**Cheshire West and Chester Council's Representation Made at  
Deadline 8**

**Submitted at Deadline 8 – 12 September 2023**

- 1.1. Cheshire West and Chester Council (**the Council**) is one of the host authorities for the for the Liverpool Bay CCS Limited's (**the Applicant**) HyNet Carbon Dioxide Pipeline DCO project (**the Project**)
- 1.2. This document is the Council's Written Representations, submitted at Deadline 8 of the Examination into the DCO.

**DRAWING TITLE**  
 Figure17.7: Road Diversions Sheet 5 of 8

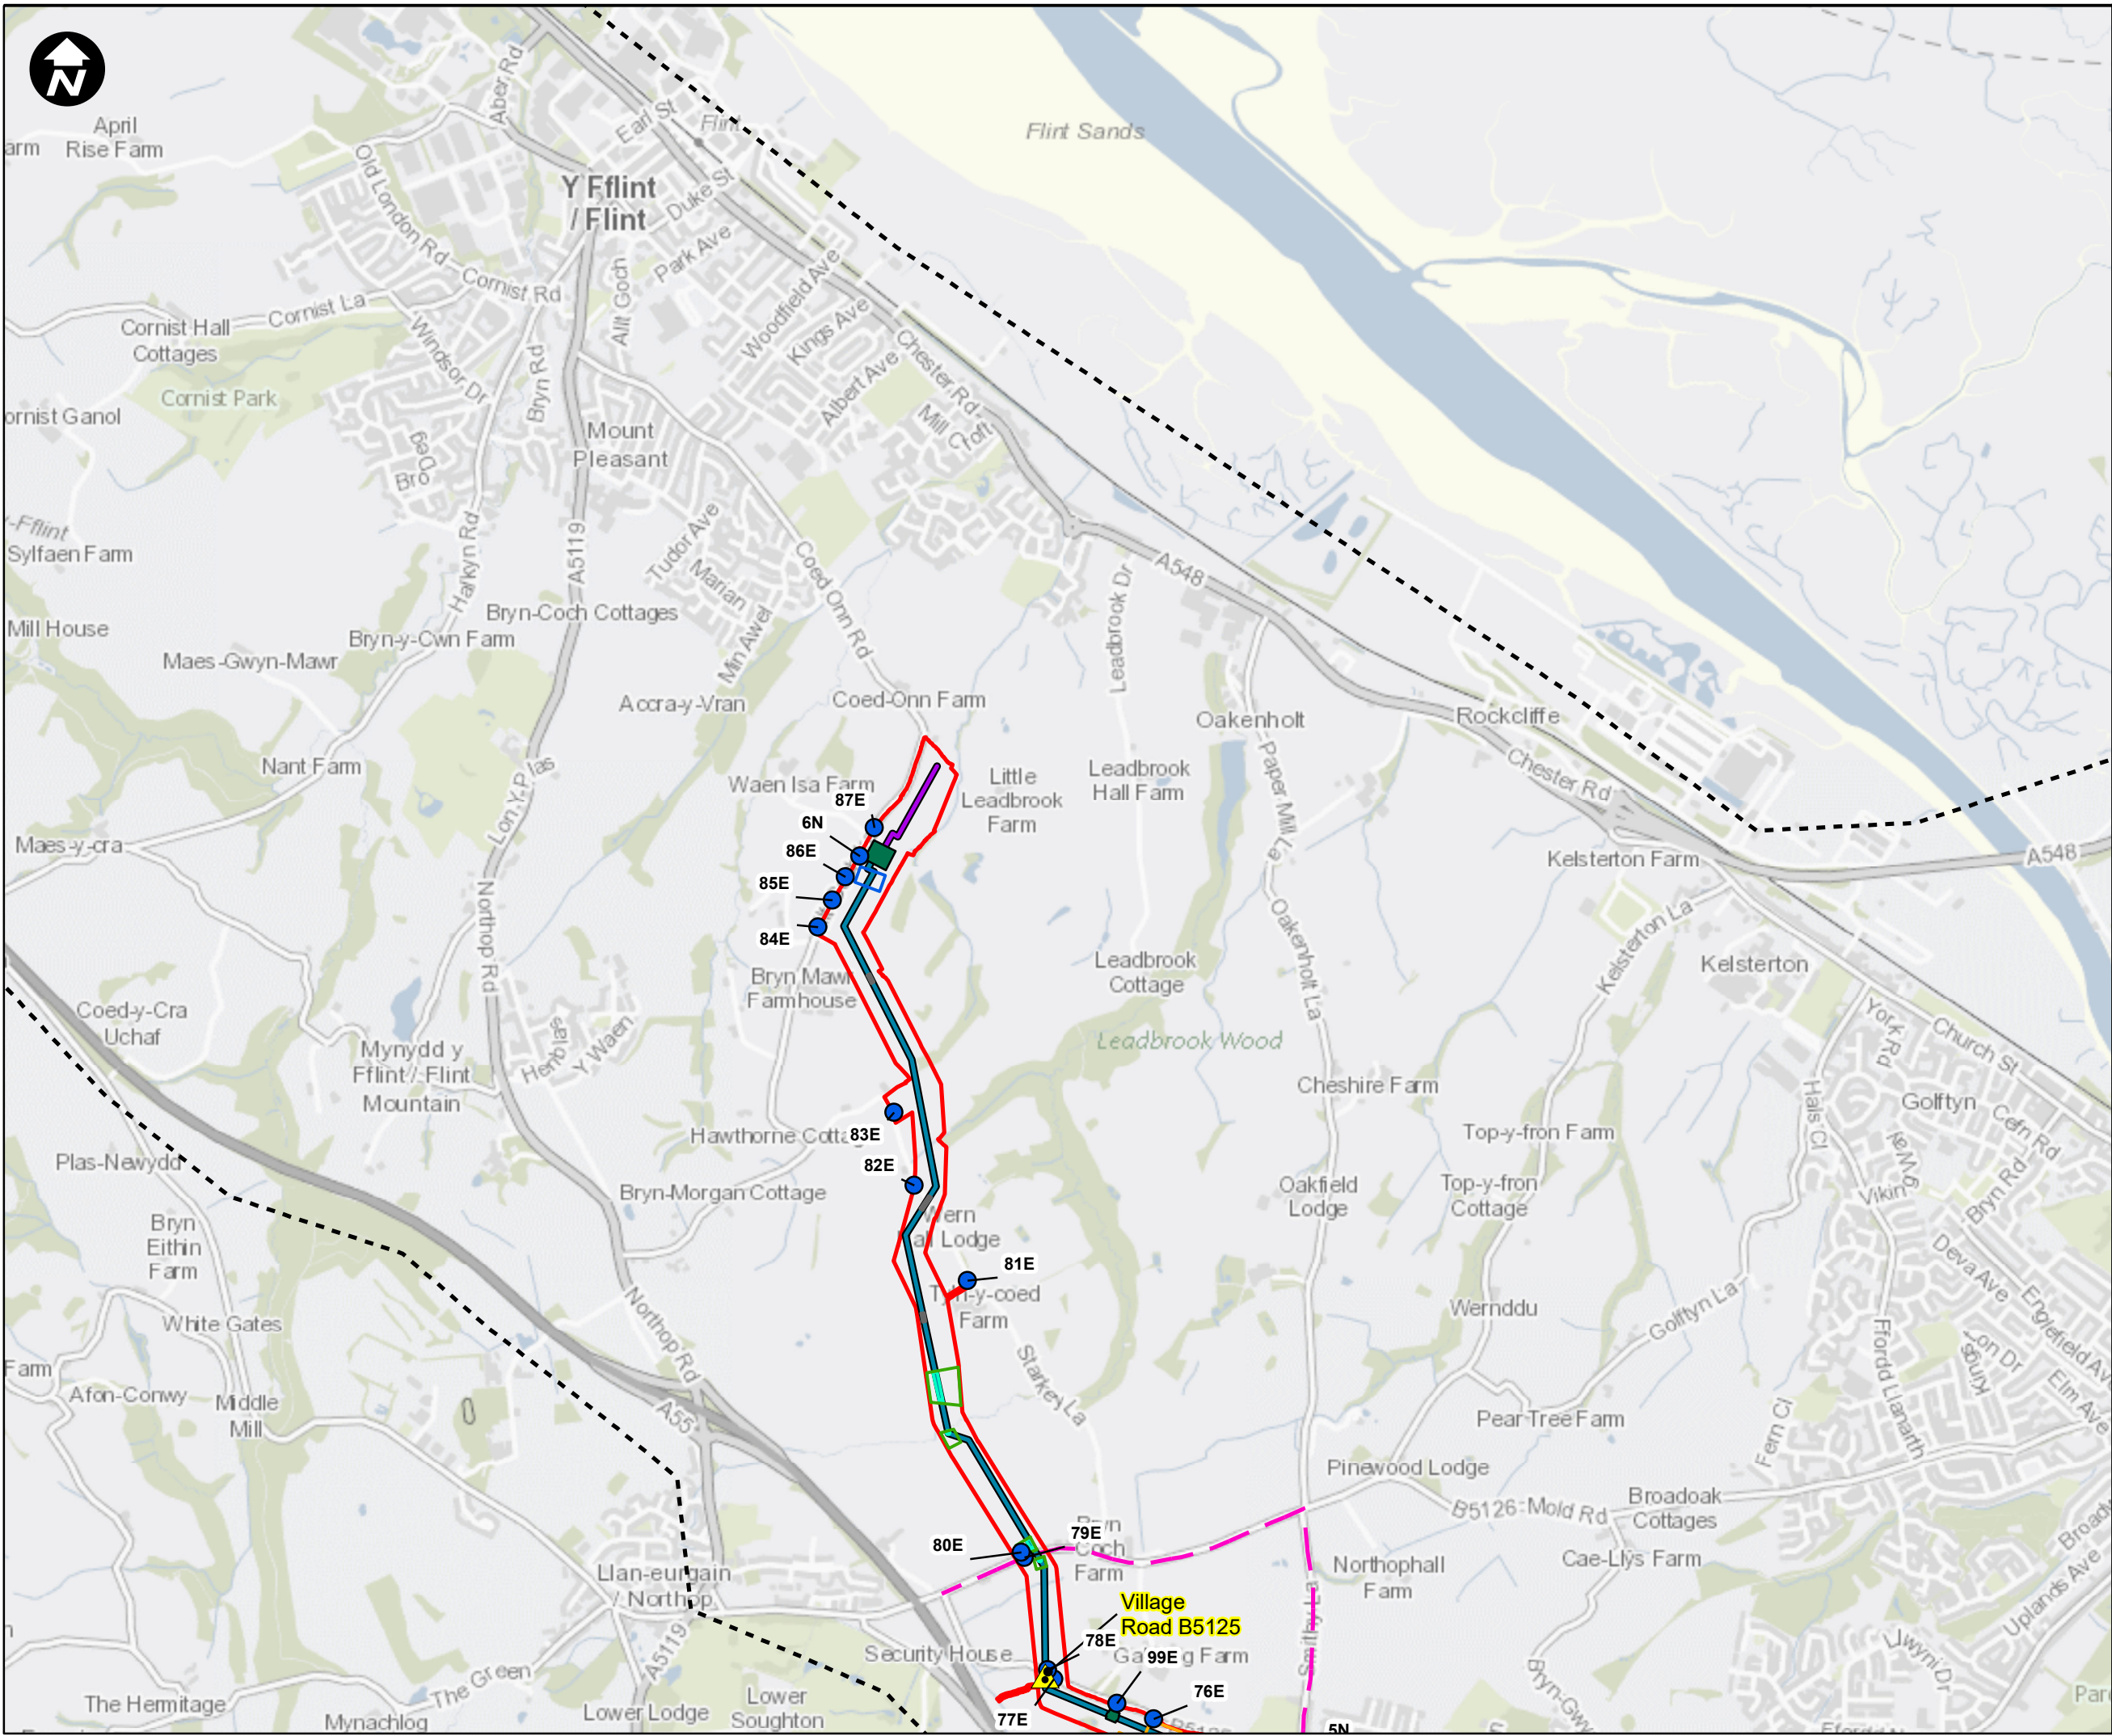
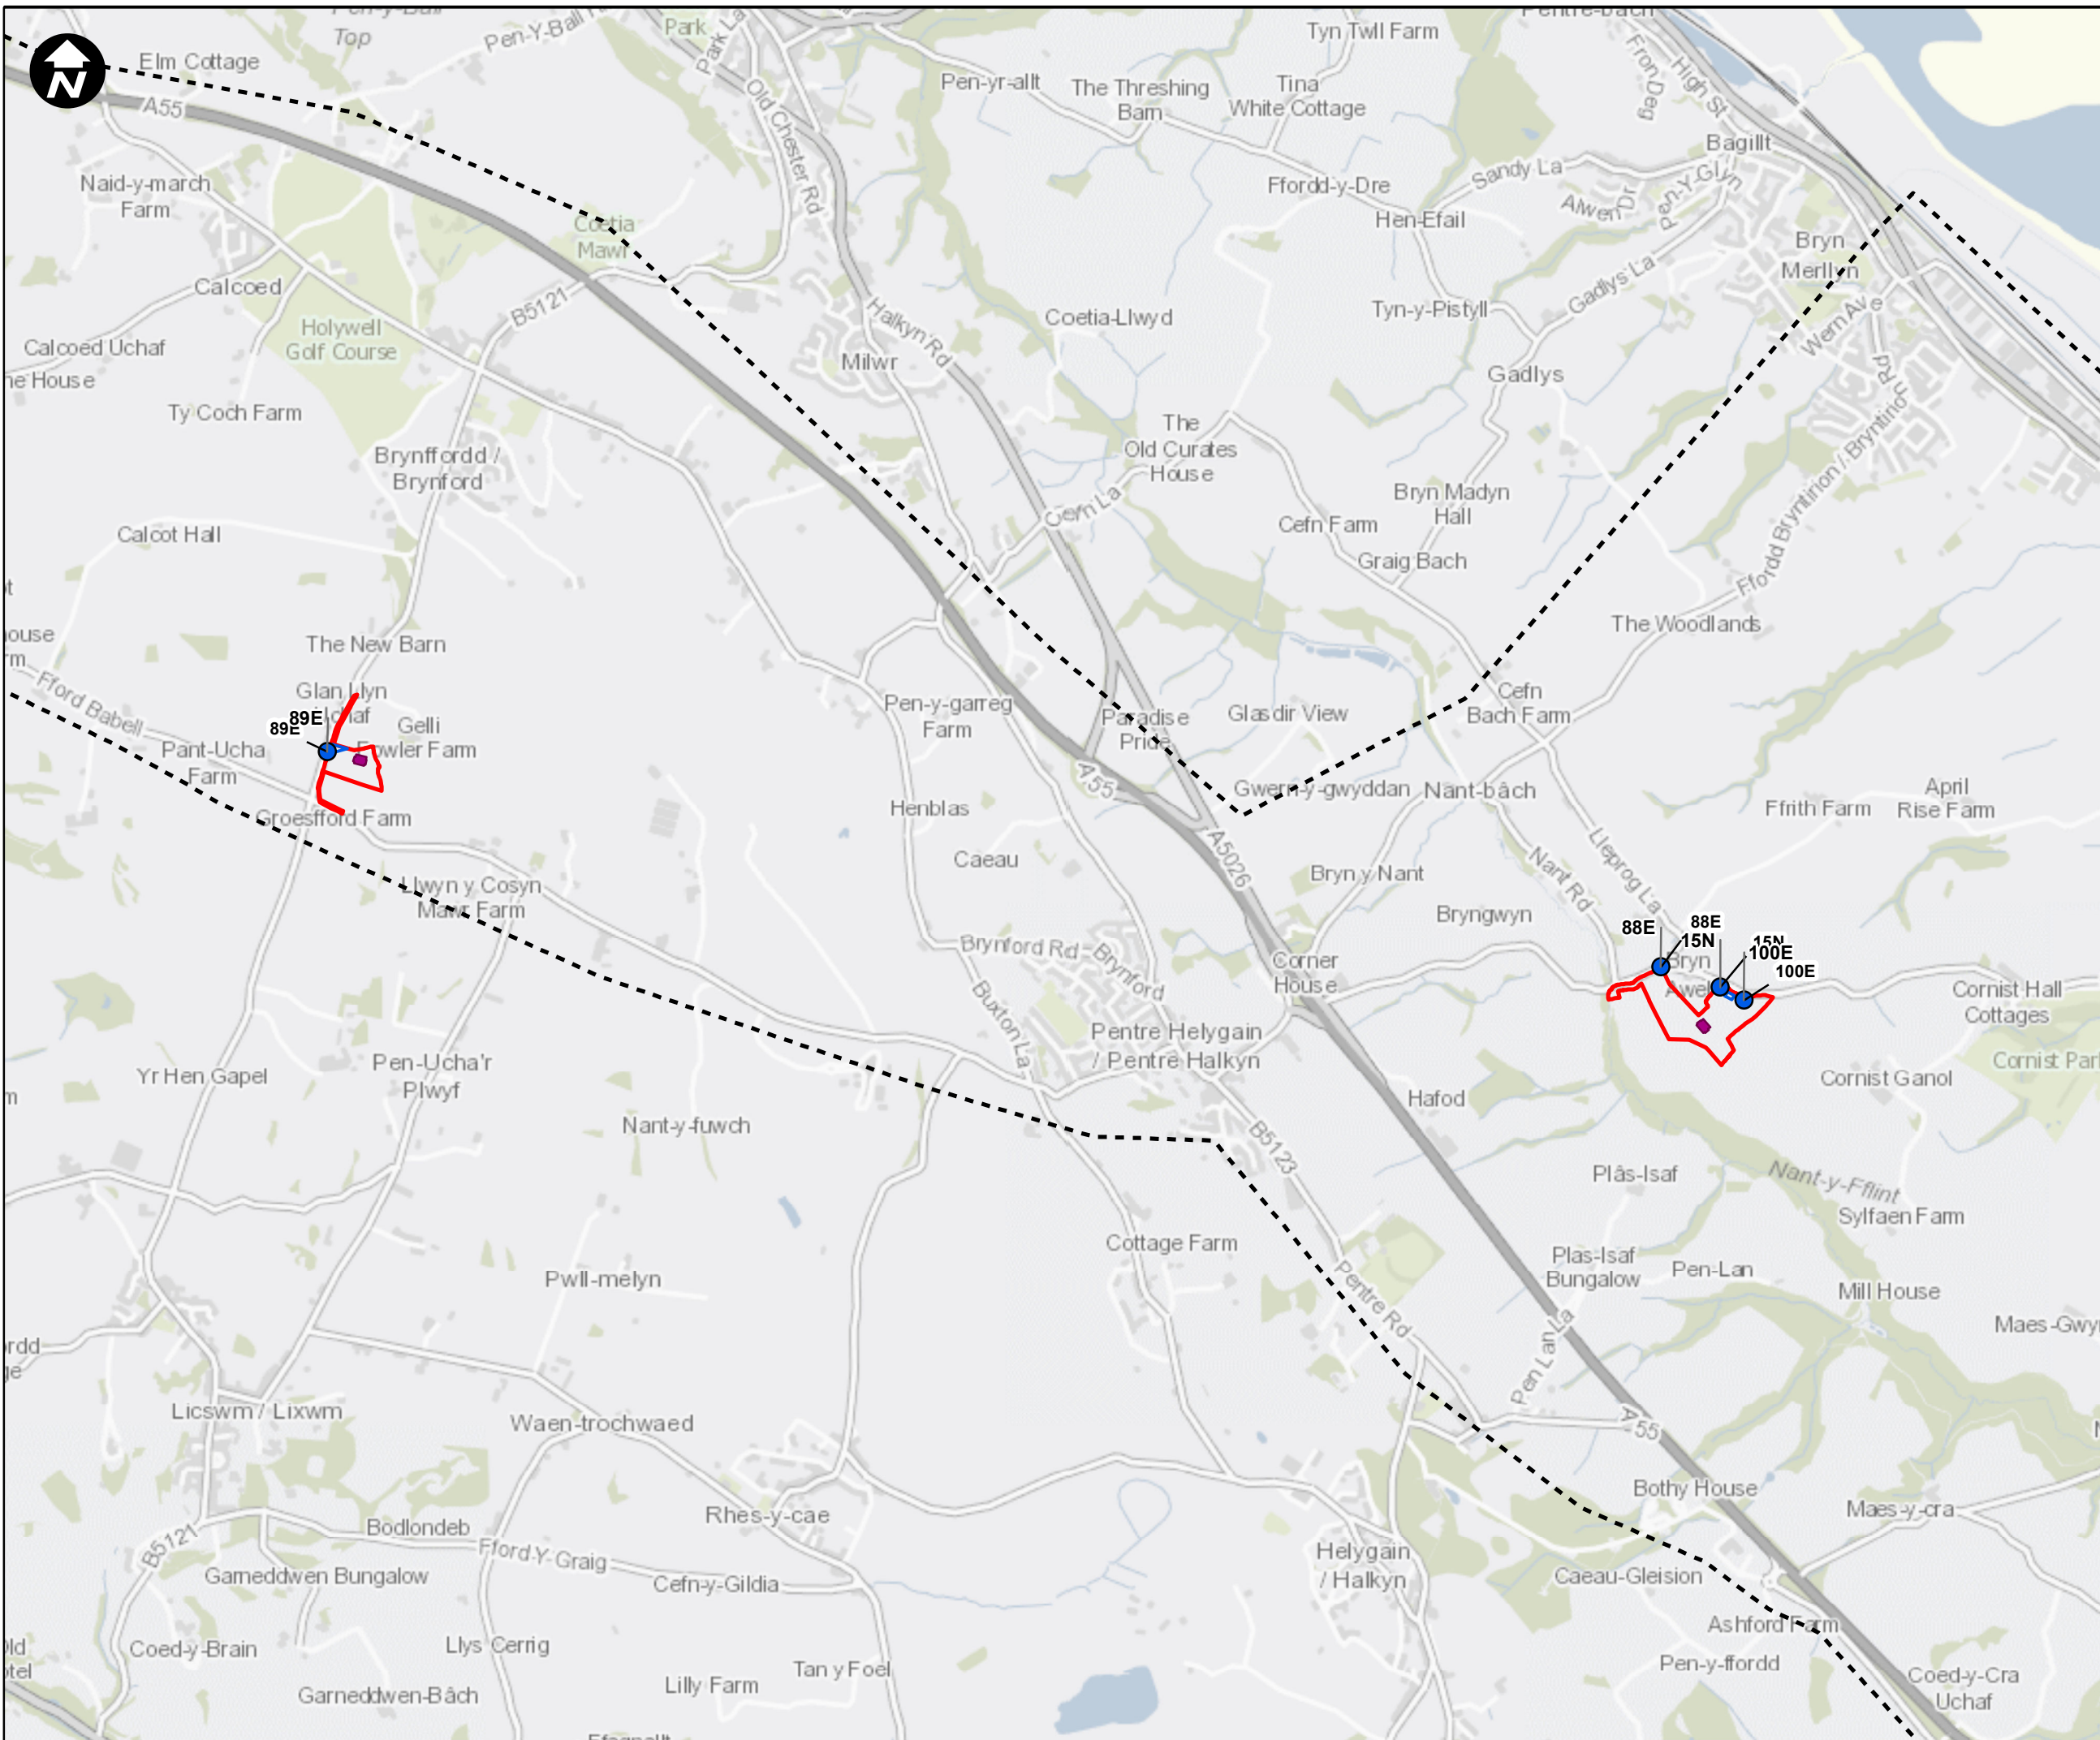
Paragraph	Text	The Councils Response
5.5.3	These are presented in <b>Figure 17-7 - Road Diversions (Volume IV of the ES) [CR1-095]</b> .	The Council notes that the diversion routes included have not been indexed and is not clear which route is used for which closure.

7.3.4	The following mitigation is proposed:  <ul style="list-style-type: none"> <li>• During the Construction Stage, advanced warning signage will be implemented to slow vehicle speeds on approach to construction accesses and warn other road users of site traffic</li> <li>• Provision of Manual for Streets (MfS) compliant visibility splays with associated verge trimming and clearance; and</li> <li>• It is recommended that 'Slow' road markings on the eastbound approach to the permanent access location to reduce 85th percentile speeds are implemented for the operation and maintenance stage of the DCO Proposed Development.</li> </ul>	The Council notes that the CC CTR 2 and BVS CTR 1 routes are incorrect and they do not account for one-way systems, hence the Council requiring detailed diversion route indexed per closure/works location.
